## RESPONSE TO SUBMISSIONS – ASPECT INDUSTRIAL ESTATE – LOTS 54-58, DP259135 – MAMRE ROAD – KEMPS CREEK

Please see below responses to key items raised within TfNSW' letter dated 4 November 2021 (TfNSW reference: SYD19/01350/24).

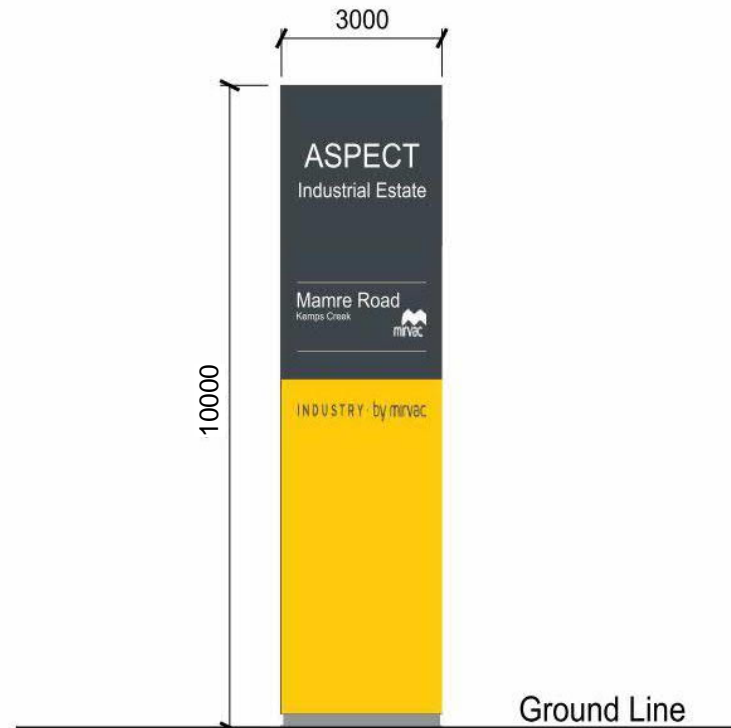
TfNSW reiterates the comment provided in TfNSW letter dated 29 March 2021 regarding access to warehousing along the Access Road 1. The response to RFI provided by Ason Group received on the 7 June does not justify why there is a need to retain the proposed multiple access points along the 'High Order Road.'

TfNSW remains concerned with the number of conflict points along Access Road 1, particularly within proximity to the Signalised intersection at Mamre Road for safety and efficiency reasons

TfNSW notes that the Road 1 is a "High Order Road" or primary (collector) road as stated in the Mamre Road Precinct DCP. The DCP also states Driveways should be provided from lanes and secondary streets rather than the primary street, wherever practical. In this regard TfNSW would not support multiple access points along the collector road Road 1.

In addition the access point to Warehouse 1 carpark is located in close proximity to the proposed signals and would not be supported.

Mirvac have considered the access requirements within the DCP and have subsequently amended the concept masterplan to amend, remove or relocate key access points to AIE Collector Road No.1 where appropriate and possible inline with the DCP and TfNSW comments. Refer attached revised AIE concept masterplan.

As outlined within the DCP Section 4.6.2 control No.4, and discussed with TfNSW at meeting on 16 November 2021, Mirvac have sought to amend the access to Warehouse No.1 as follows:

- Access to the café / western fire compliance access road to be via a dedicated left in only deceleration and slip turning lane; and
- Access to Warehouse No.1 southern carpark to be moved east of the proposed AIE access Road No.4.

It should be noted that direct access from the AIE Road No.1 Collector Road to Warehouse No.1 hardstand is unavoidable due to typical industrial user circulation requirements (i.e right hand down) and access circulation requirements to meet fire compliance standards.
